DRB CASE ACTION LOG - BLUE SHEET

PROJECT# 1009641 - 15DRB-70152 MINOR - PRELIMINARY/ FINAL PLAT APPROVAL

PROJECT NAME: MRGCD MAP#35

Your request was approved on 4-15-15 by the DRB with delegation of signature(s) to the following departments - outstanding comments to be addressed as follows:

PLAT OF  
TRACTS 338-B-1 AND 338-B-2  
M.R.G.C.D. MAP 35

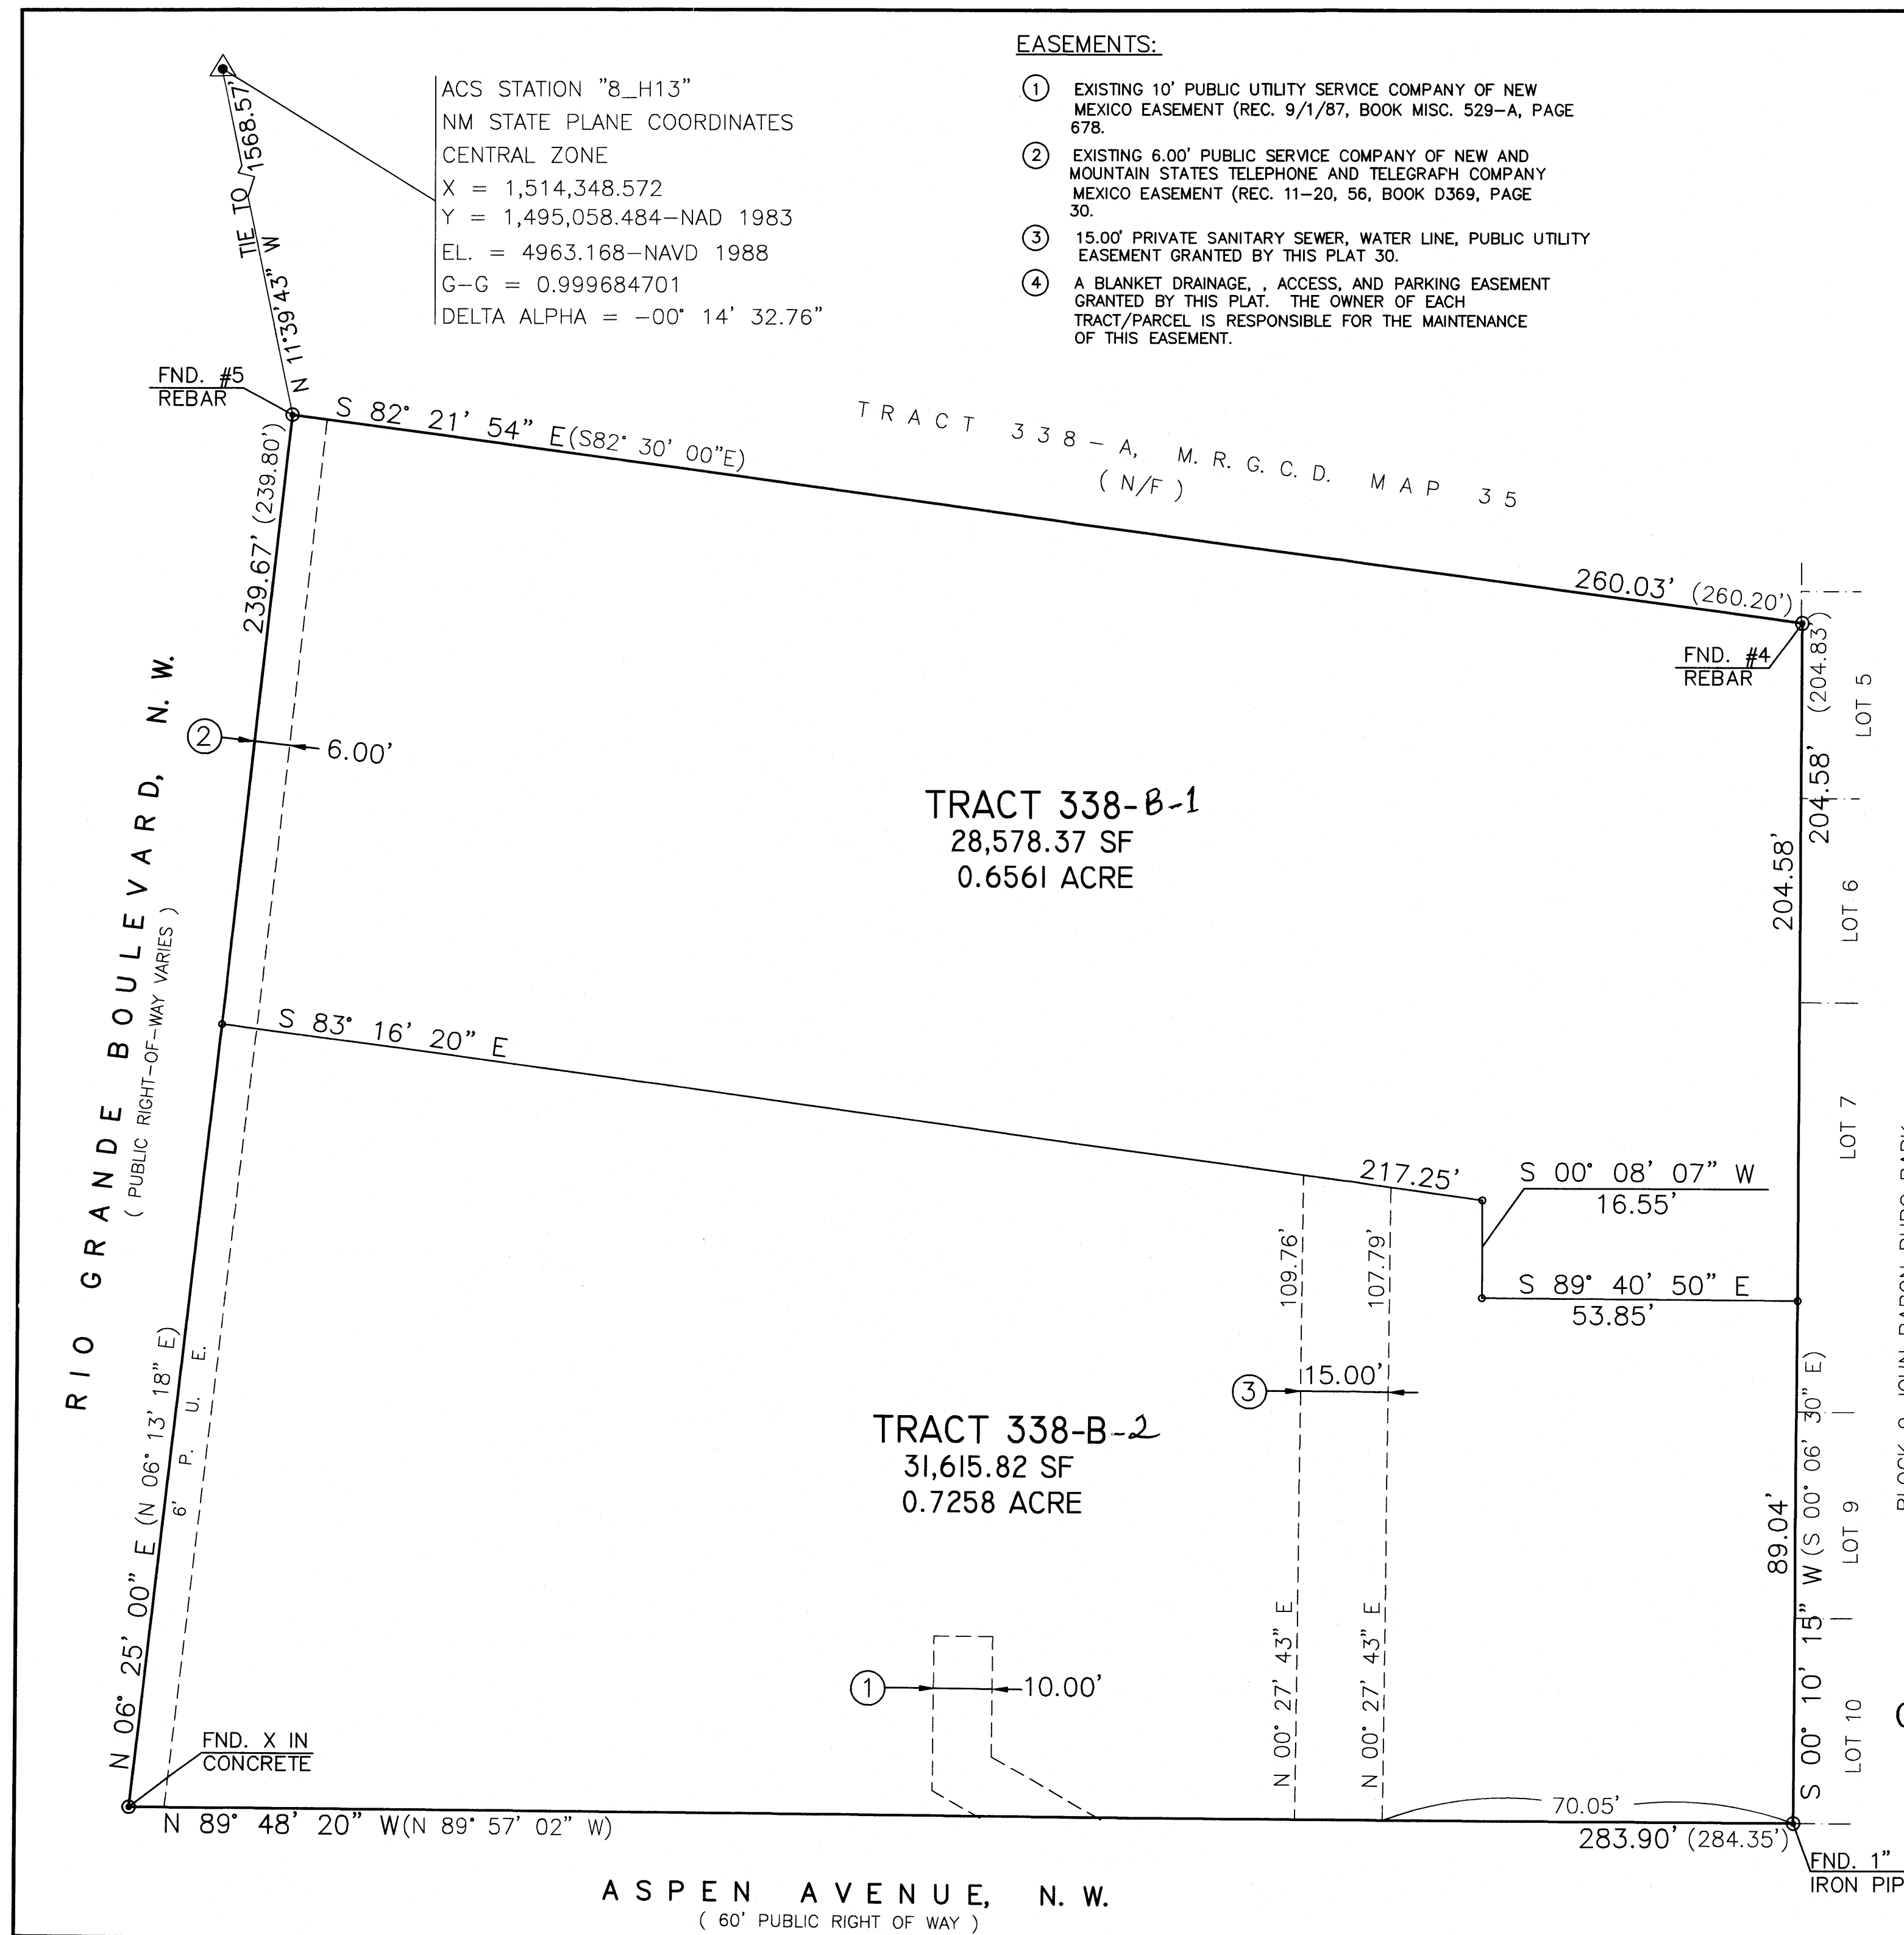
ABCWUA: acct's, revise E'ment

Planning: dedicate R-O-W radius, drainage, Hydrology, curbs, utility riprap
